**Consultation Response from KC,
Highways Development Management**

2025/91542 Land at, Highmoor Lane, Hartshead Moor, Cleckheaton, BD19 6LW

**Erection of 40 dwellings and associated works, including formation of new vehicular access
and erection of cricket netting**

Date Responded: 1-10-2025.

Phoenix 2 Duo (P2-15W with Elite 6x4 chassis)
 Overall Length 11.200m
 Overall Width 2.530m
 Overall Body Height 3.751m
 Min Body Ground Clearance 0.304m
 Track Width 2.500m
 Lock to lock time 4.00s
 Kerb to Kerb Turning Radius 9.500m

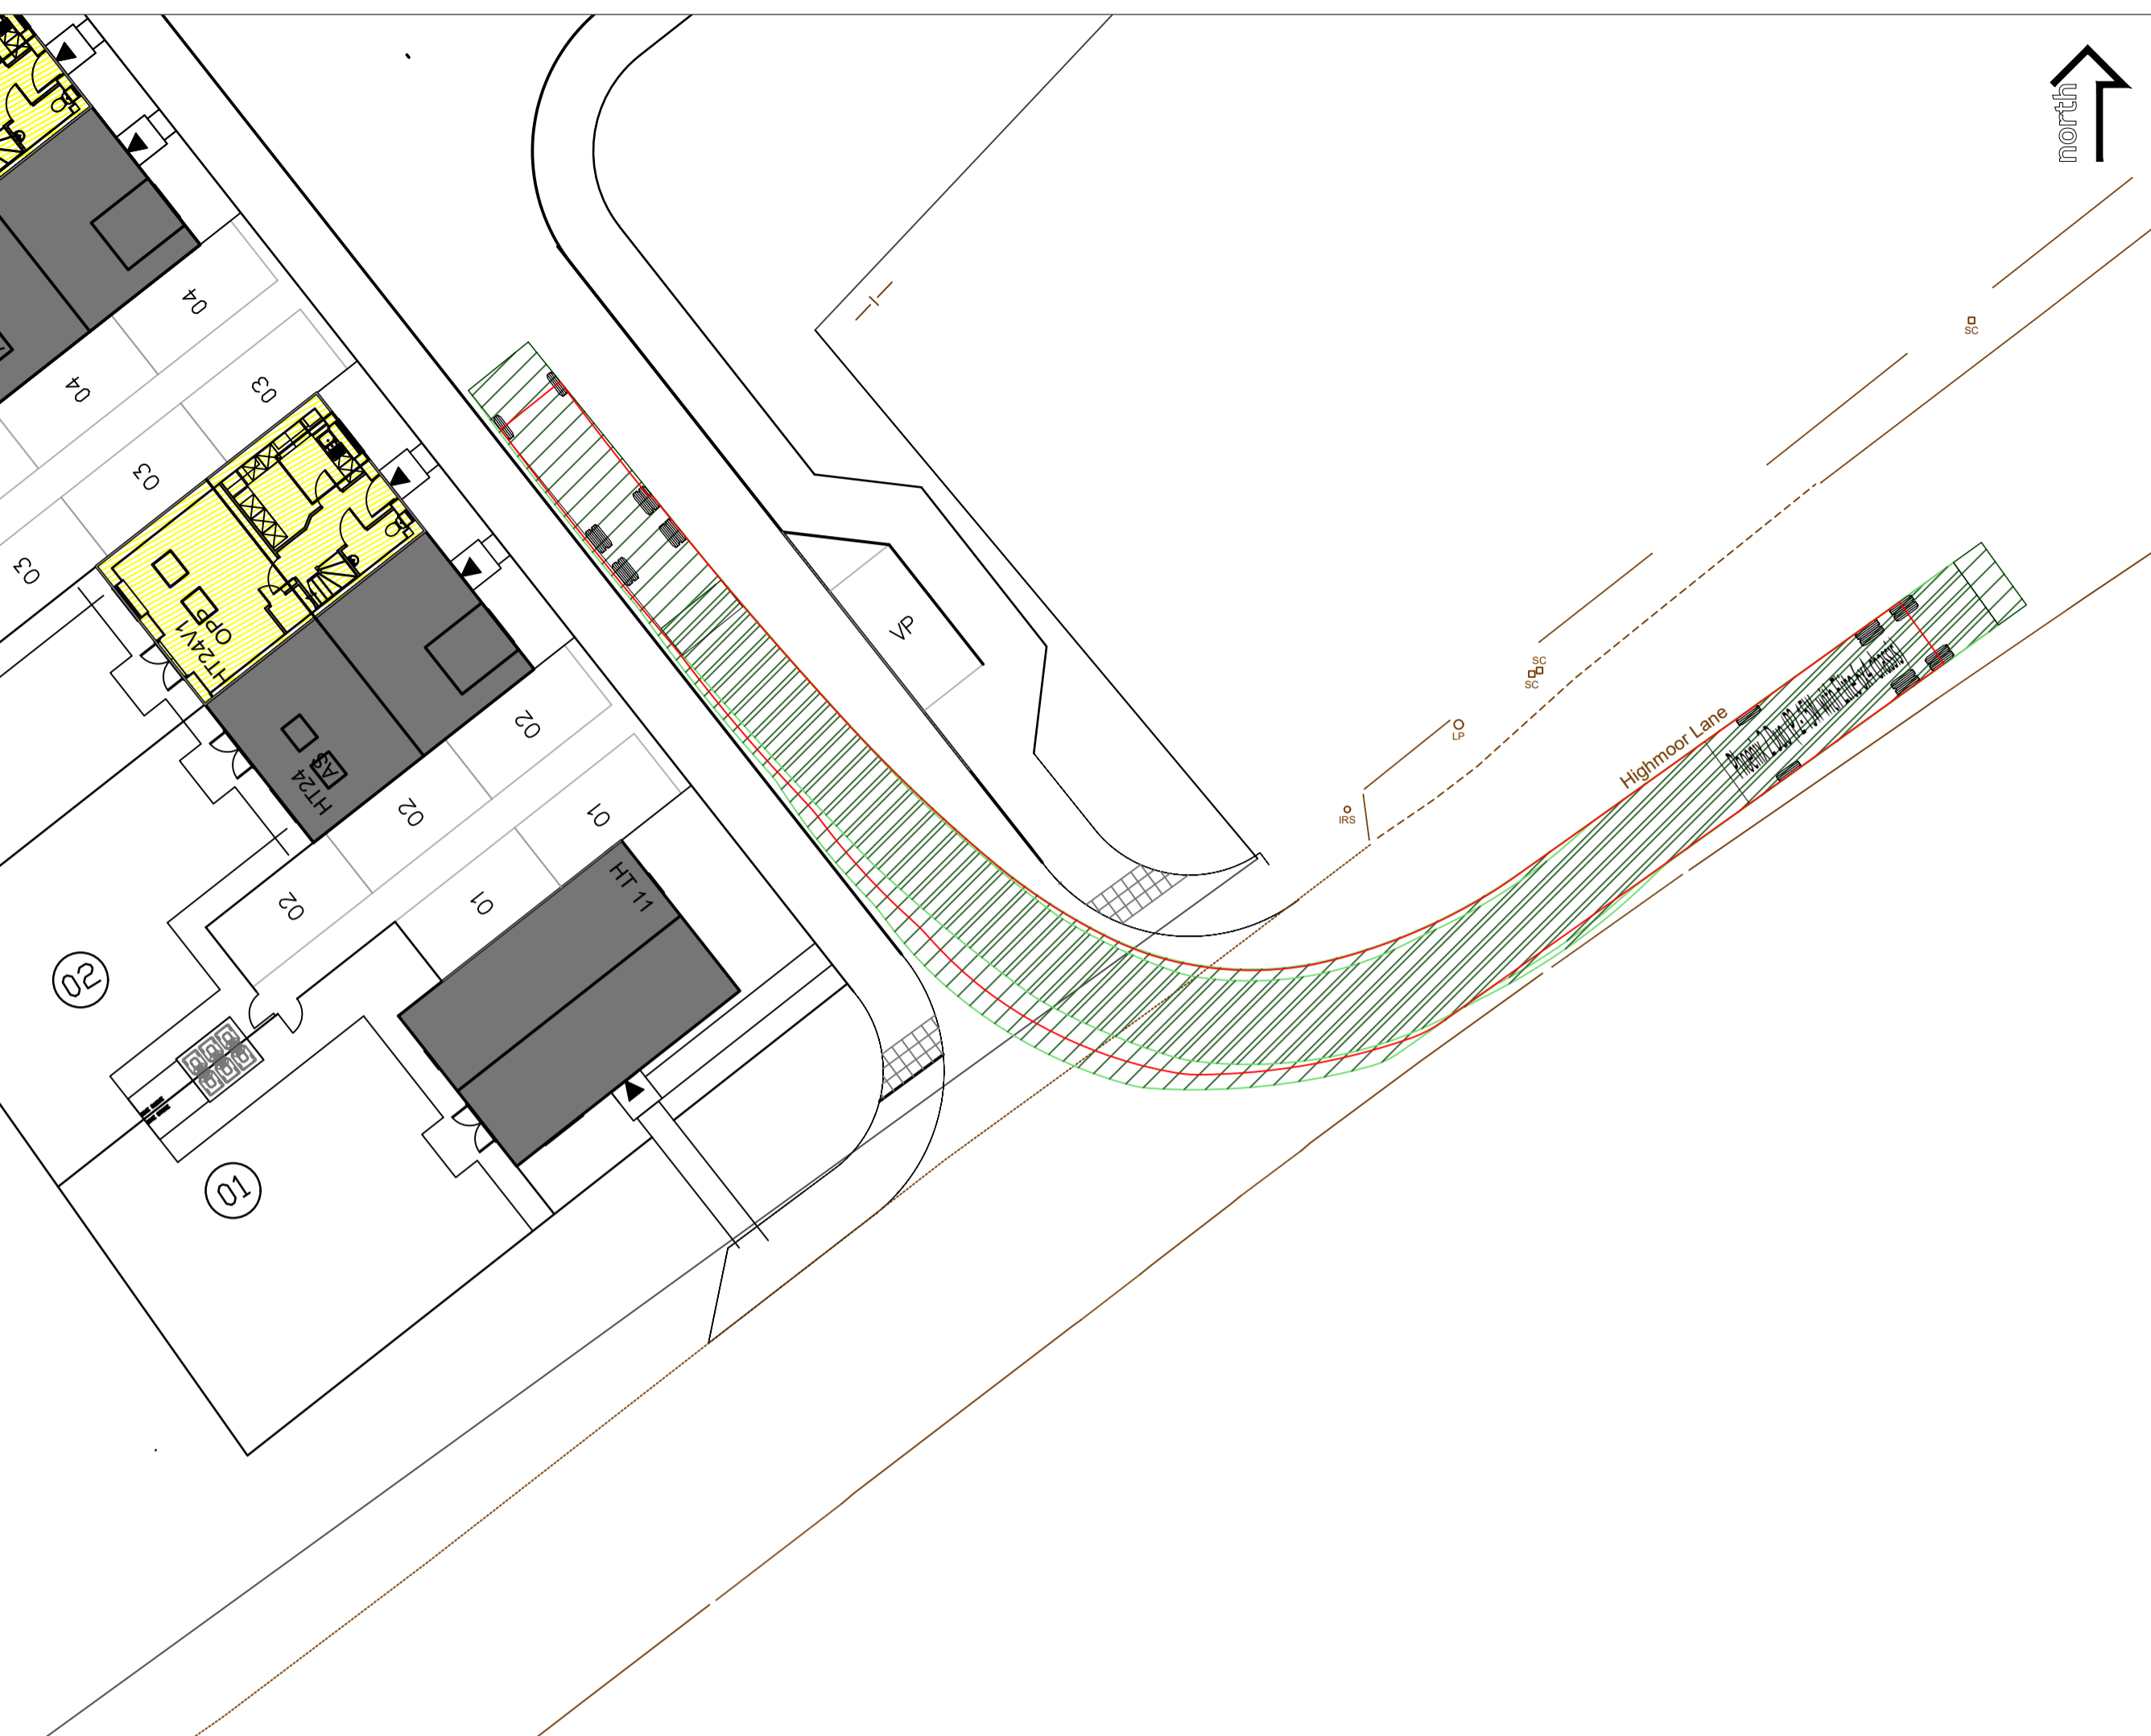
Swept paths for an 11.85m refuse vehicle should be used and not the 11.2m vehicle shown on the Transport Statement.

DRAWING TITLE
Proposed Site Layout

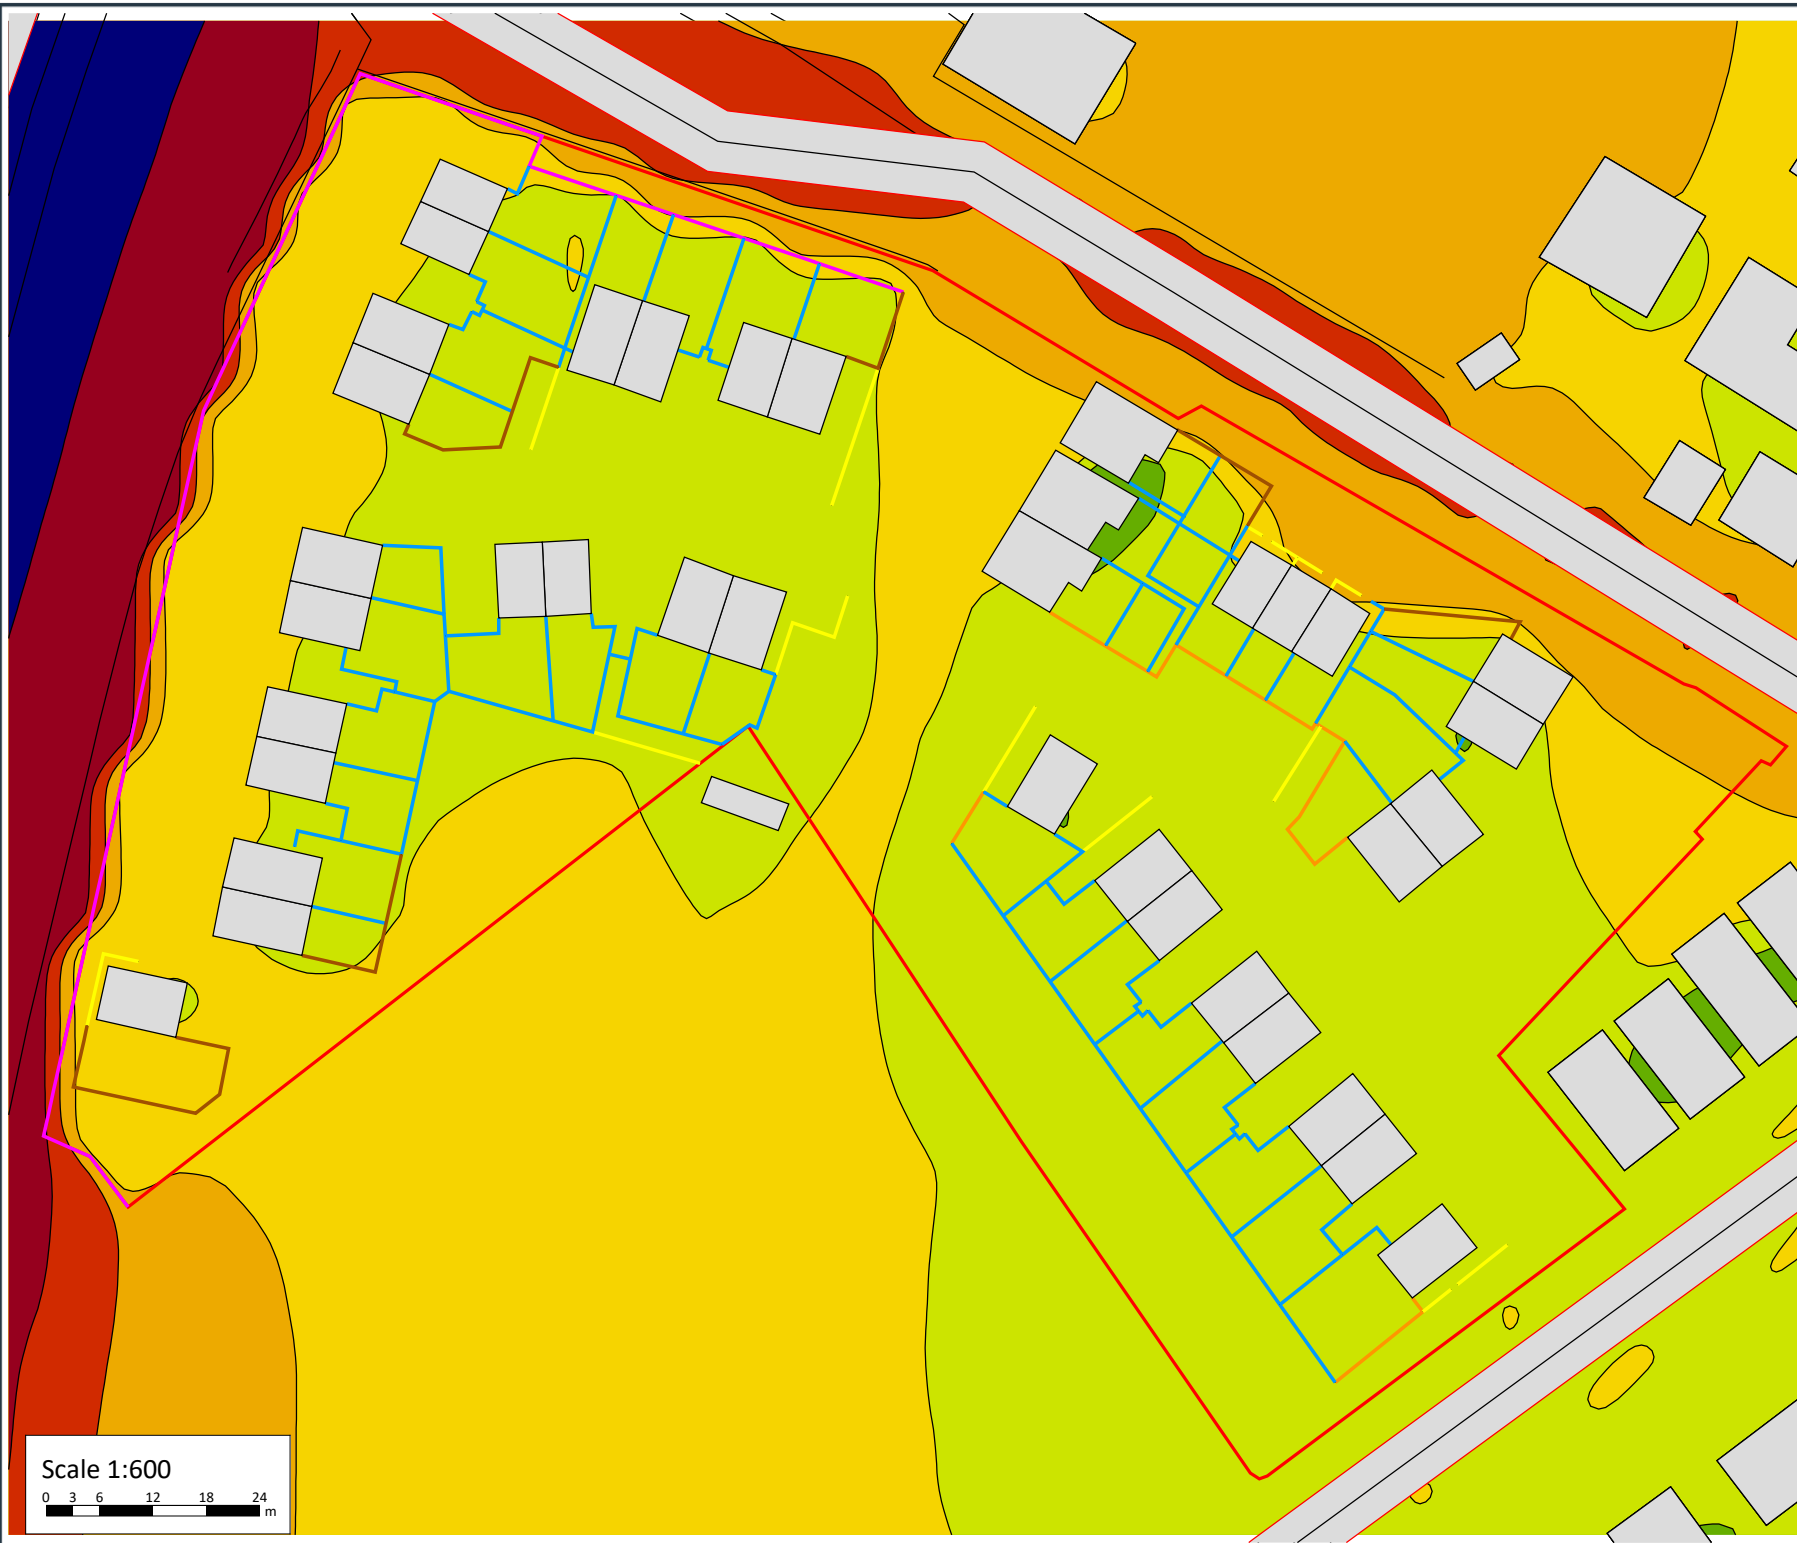
The visibility splay at the site access is incorrect. It seems to extend out to the southern side of the road, rather than to a 0.5m offset from the northern side. They are proposing to link into the existing 'footway' immediately east of the proposed access as the pedestrian route. This route is not viable or safe for pedestrians under existing conditions. Cars Park along here all the time up close to the wall; Mobility impaired pedestrians would struggle to get past. Pedestrians would be highly likely to walk along the carriageway around the outside of the cars, at risk of being struck. This should be resolved before further development is supported.

The road scales at around 6.5m wide so options are limited within the existing cross section. However, there is a wide verge along the southern side, so there is scope to widen along this side and 'move' the eastern section of the road southwards to free up width. If this was done, the Developer could provide a 1.5m wide kerbed footway along the northern side along the frontage of the existing houses, alongside a 2m parking bay, a 6.5m wide carriageway, and physical buildouts at either side of their own junction (with a taper leading into the western side), to resolve both the visibility and pedestrian route issues.

Footways will be required on both sides of the Local Residential Street (Type B) carriageway to a minimum width of 2.0m as per Table 1. It is noted that there is only a footway on one side of the road and so this will be rejected if a S38 adoption application is made. Given the gradient of this road is not steeper than 5% the applicant may want to consider amending parts of this road to a shared surface (Type C) where only 600mm margins are required but the carriageway must be block paved.

The short stub road serving plots 9 to 12 is laid out as an adoptable road. This can be private driveway given it just serves 4 dwellings.

Turn heads for a delivery van should be shown to be provided to all shared private driveways.
